City of Albuquerque

November 15, 1985

RE: DRAINAGE PLAN FOR KELEHER EXECUTIVE CENTER
SUBMITTED OCTOBER 22, 1985 FOR BUILDING PERMIT APPROVAL
(J-14/D56)

**DUPLEX SUMP PUMP & BASIN DETAIL**

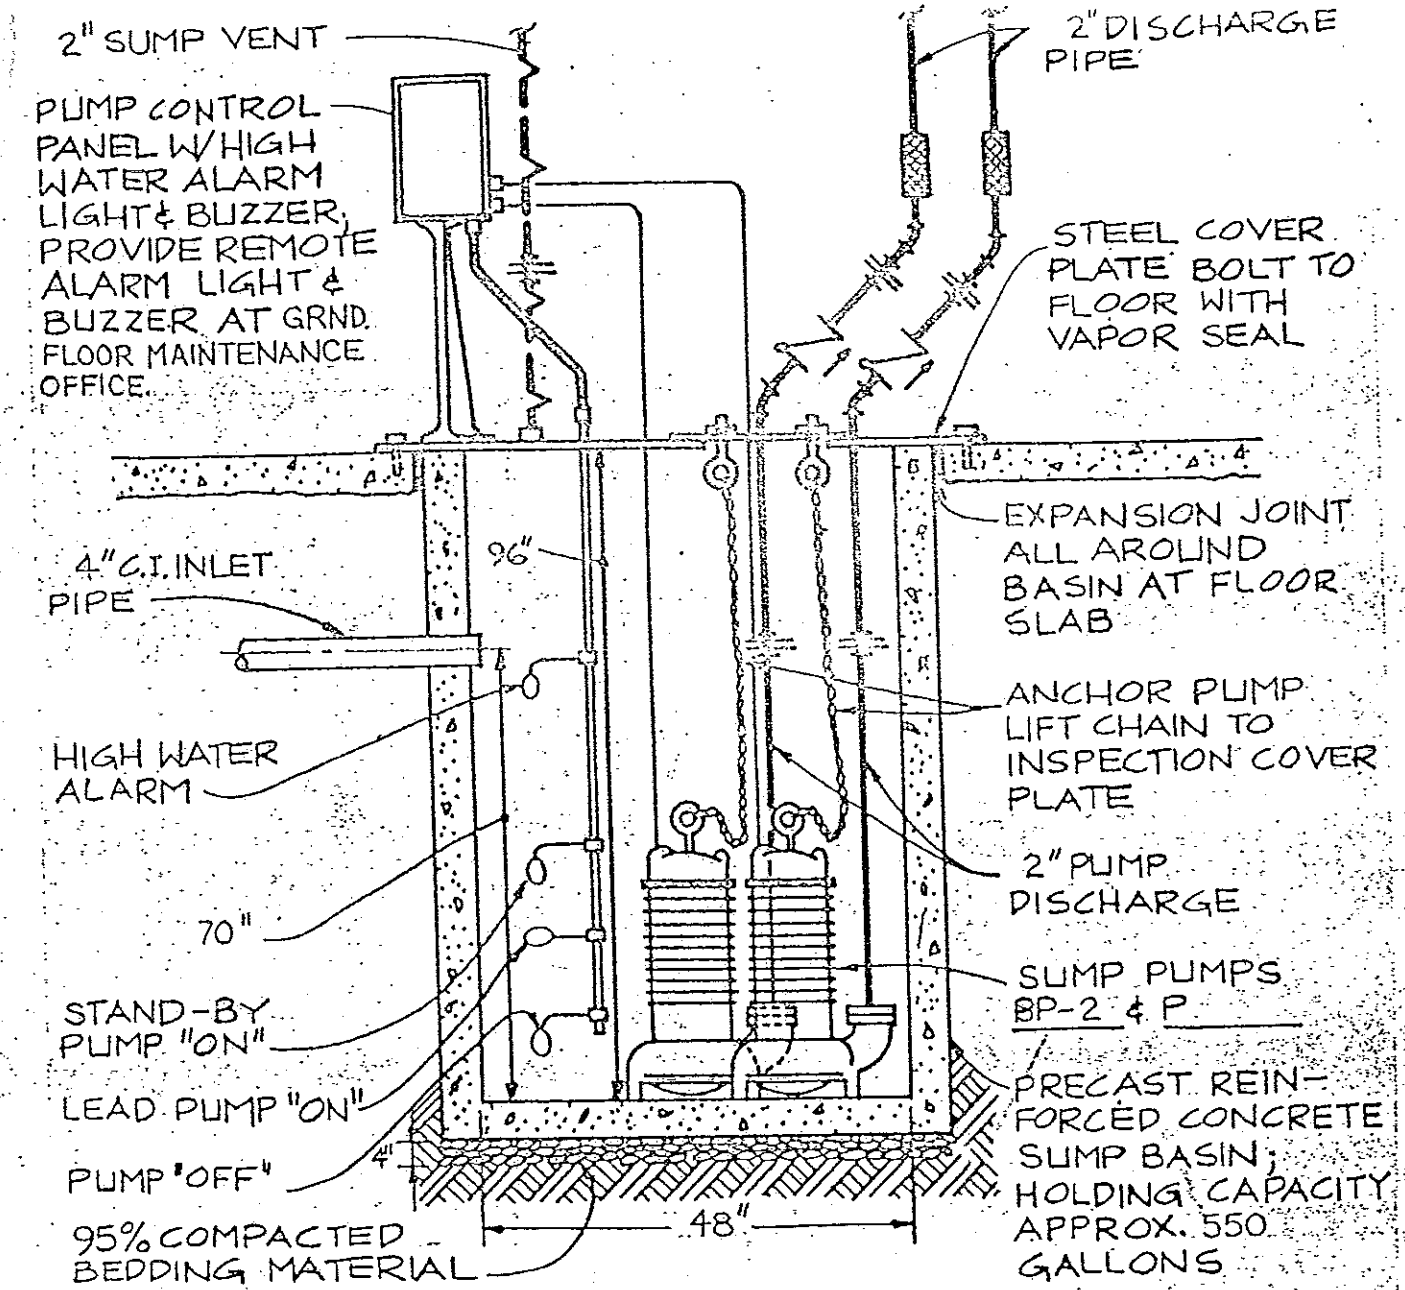
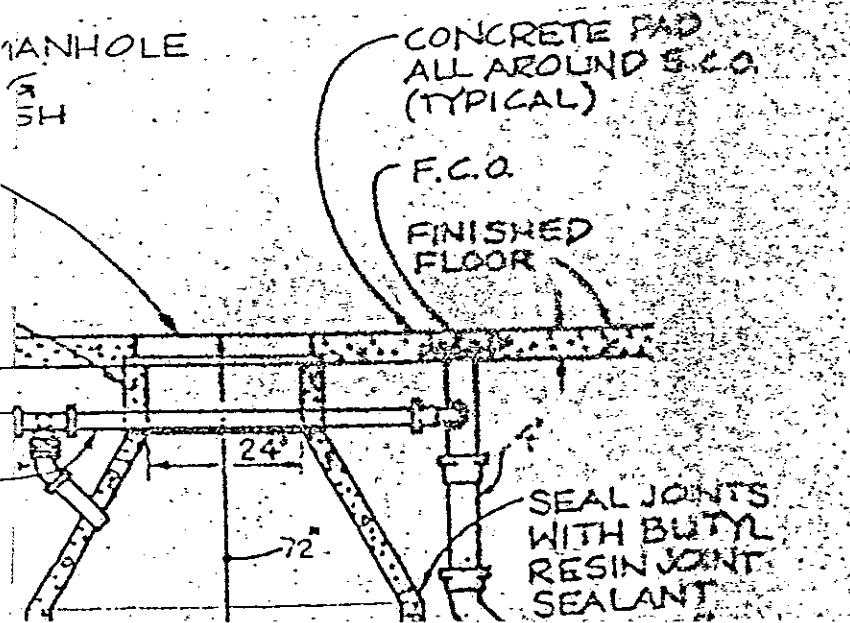
1. City of Albuquerque Flood Hazard Ordinance requires that the lower level parking area down ramp be protected to 1' above the 1' flood depth, or a total of 2' above gutter flow line. Drainage Plan specifies only 1' instead of 2'.
2. Since the pump in lower level and the 8" diameter pipe into existing catch basin are integral parts of the drainage scheme, provide detailed sump design and pump rating curves along with hydraulic designs, to verify adequacy of proposed sizes.
3. Provide runoff volume of drainage areas in addition to peak runoff rates per the DPM.
4. The 8" diameter drainage line must have a check valve between the junction with the roof drains and discharge line from pump.

**GRADING AND DRAINAGE PLAN**  
**LOWER LEVEL**  
SCANLON & ASSOCIATES  
CONSULTING ENGINEERS

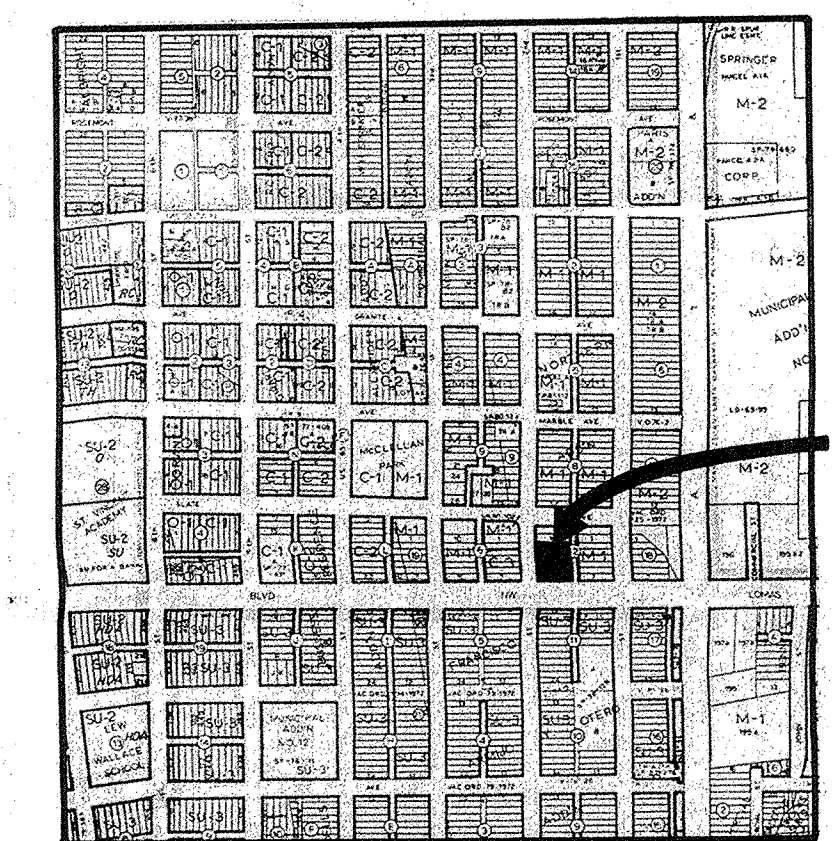
5. Since a valley gutter is proposed at the northwest corner of site to carry off-site nuisance flows, a sidewalk and curb drain is recommended between end of valley gutter and street.
6. Before building permit can be approved, evidence that lots have been replatted to remove lot lines must be provided to this office. Replatting will require approval by DRB.
